**KIRKLEES METROPOLITAN COUNCIL
INVESTMENT & REGENERATION SERVICE**

DELEGATED DECISION TO DETERMINE PLANNING APPLICATIONS

Reference No:	2024/62/91664/W
Site Address:	26, Greenhill Bank Road, New Mill, Holmfirth, HD9 1ER
Description:	Change of use of land to residential curtilage and erection of part single and part two storey side extension including associated alterations
Recommending Officer:	John Holmes

DECISION - REFUSED

Cellar Plan

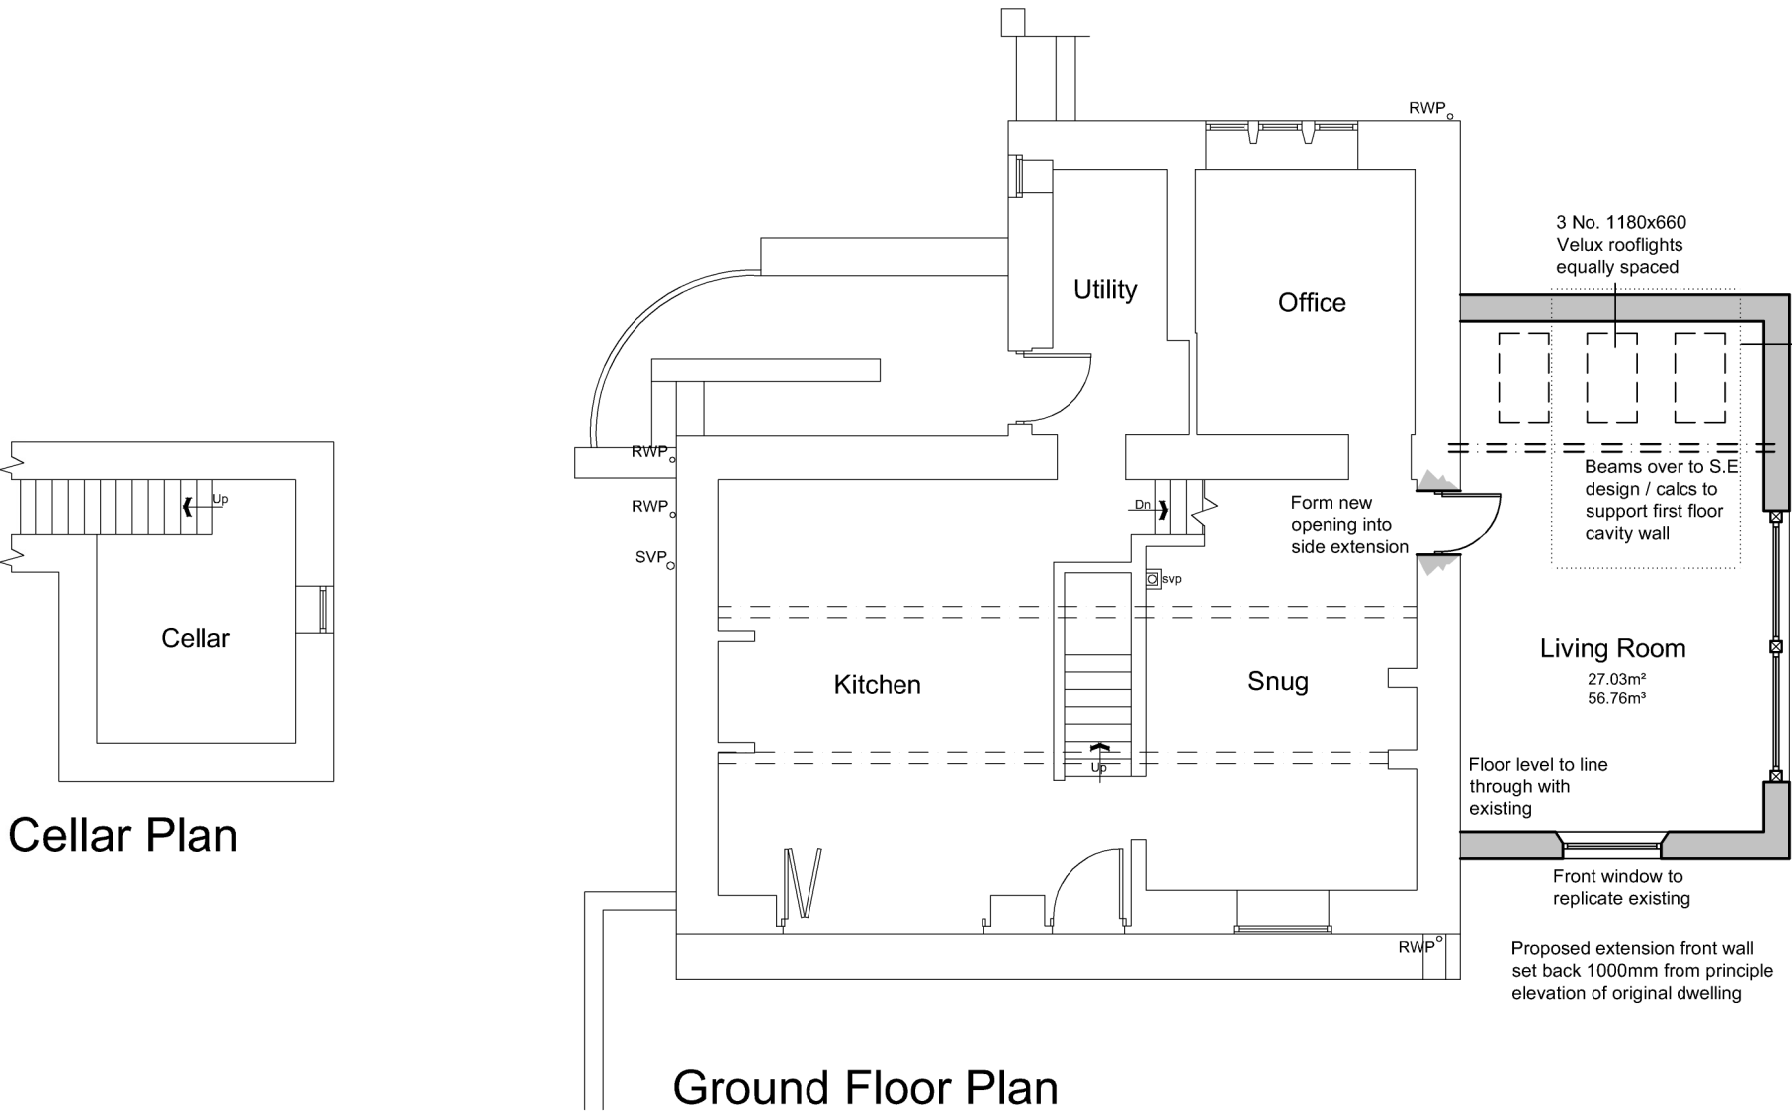
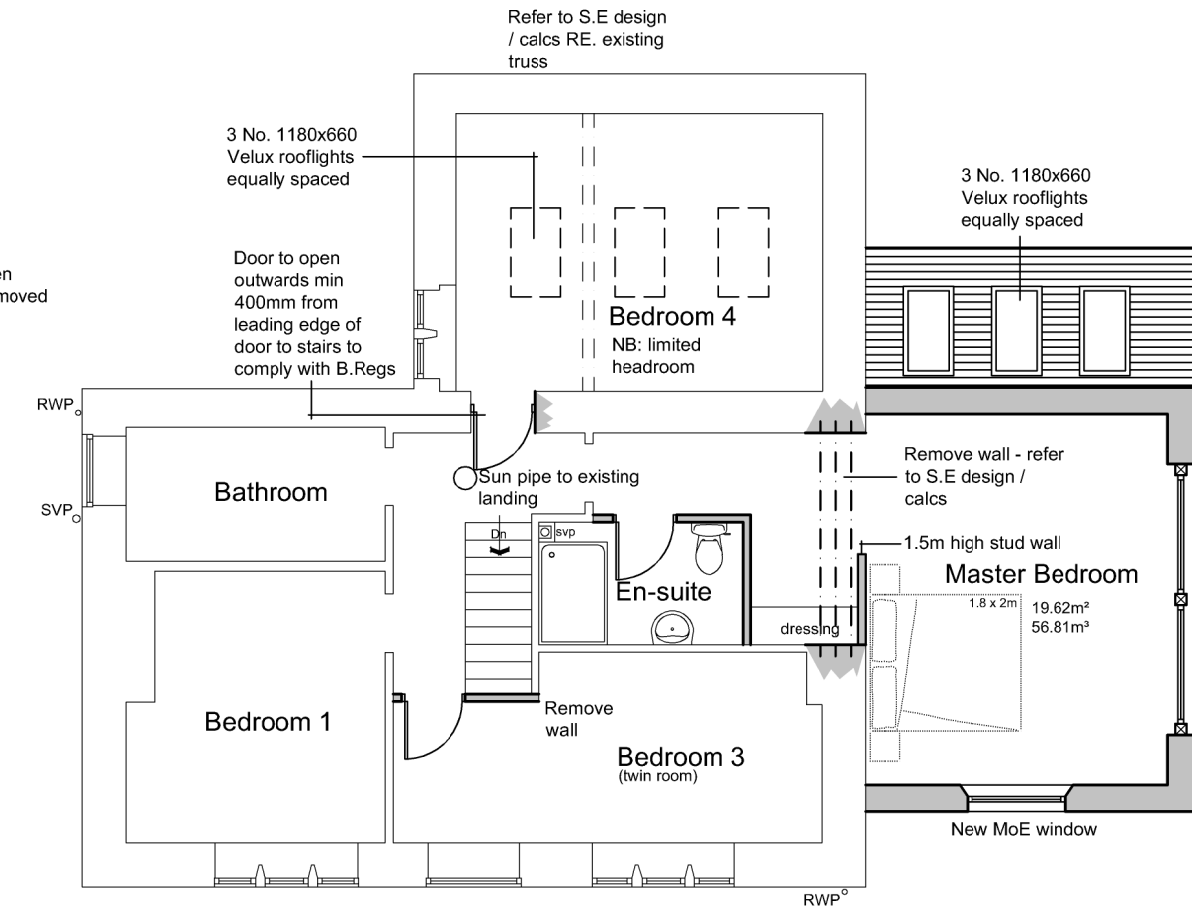
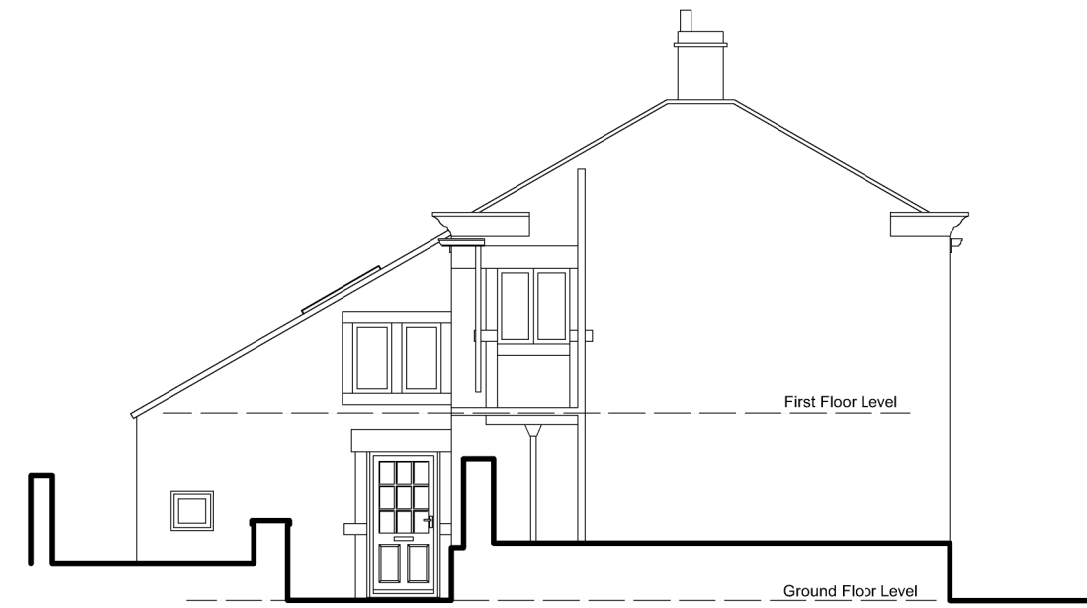
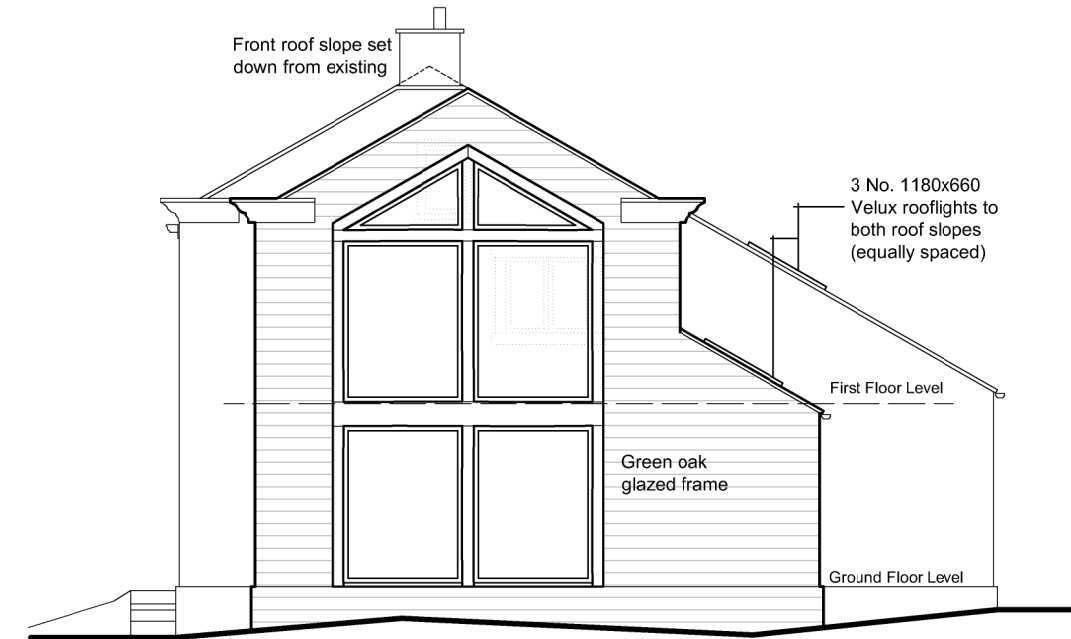
When the total volume of the previous additions (105m³) and those proposed as part of this application (180m³) are compared against that of the original dwelling (528m³). There would be an additional bulk and massing of built form resulting from the proposal, increasing that of the original dwelling by 285m³ (53%).

The previously refused sought a wider extension with an increased use of glazing / timber which protruded forward of the host dwelling. The scheme the subject of this proposal has reduced the extent of the projection to the side and is set back from the front elevation with a ridge height below that of the host property. The predominant design and materials are in keeping with the host property with design features of the host property replicated.

It is considered that the visual impact of the development in terms of the use of the materials and being designed to be of a style / design which is in keeping with the host property is acceptable having regard to the aforementioned policies.

In terms of overlooking, the openings in the two storey side extension would be to the front and side which face open land. Roof lights are proposed to the rear roof slope which would face towards the property to the north / west of the site, however it is considered these a predominantly for the purpose of providing light and given the angle they would be sited at, as well as the height in relation to the internal floor level it is not considered they would lead to a significant level of overlooking.

Proposed Block Plan

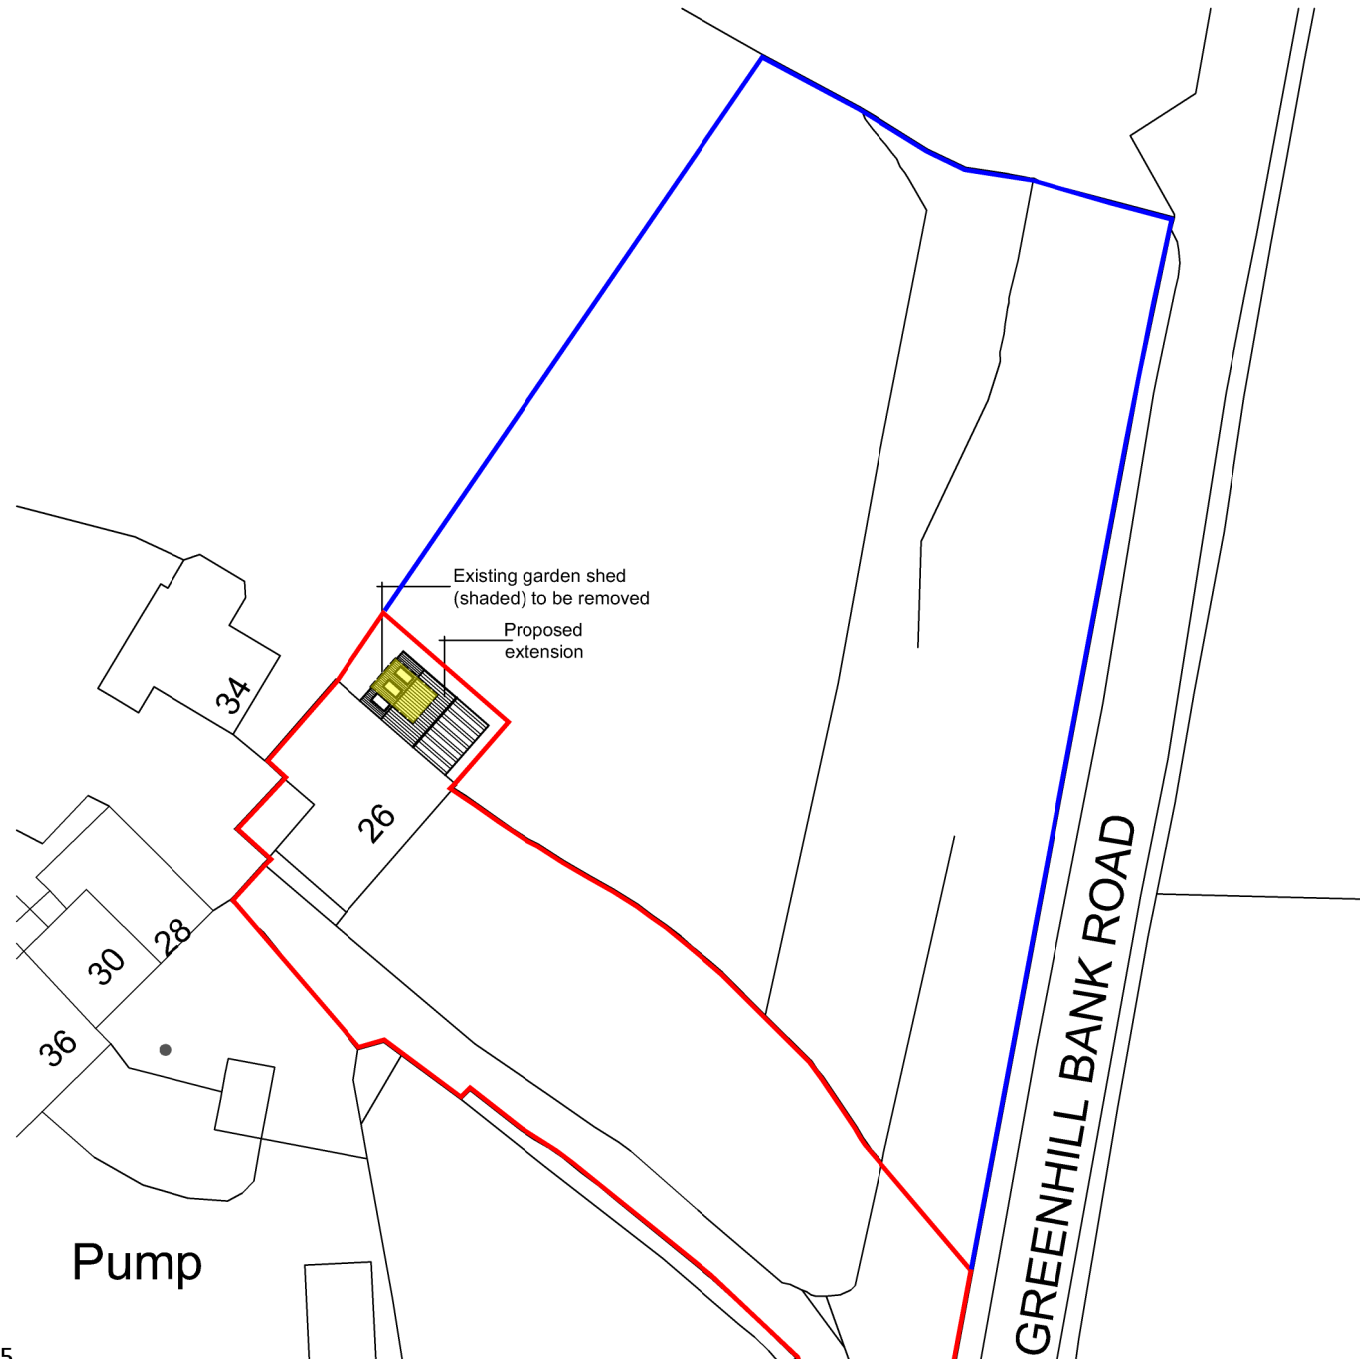
It is considered the key issue in relation to this case is whether the proposal would go beyond the extent of the established curtilage of the site. And whether the change of use of the land to residential curtilage with associated built form extensions would be acceptable.

The previous application (ref: 2021/93965) was refused, in part, on the basis that harm would be caused to the visual and spatial openness of the Green Belt by developing land that is currently open and, in part, the encroachment of development into the countryside (side extension). This assessment was on the basis that the development of the side extension was on land outside of the curtilage of the dwelling. This is relevant in the consideration of this case given the proposal which is the subject of this application is on the same area of land.

It is considered that the proposal would have a significant impact upon openness given the increase in built form associated with the dwelling and the fact it would encroach into currently open land. It is considered the proposal would have a harmful impact upon both the spatial and visual aspects of the openness of the Green Belt. The two-storey extension to side is considered to lead to encroachment of built form into the visual countryside contrary to one of the purposes of including land within the Green Belt.

Namely, in this case, the development requires the change of use of land which is not residential curtilage to accommodate it and would see further sprawl of built form within the Green Belt.

The application site is clearly identified as being land which forms part of the open countryside, a permitted development fall back has not been able to be established in relation to development of this part of the site. This is considered to weigh significantly against the proposal.
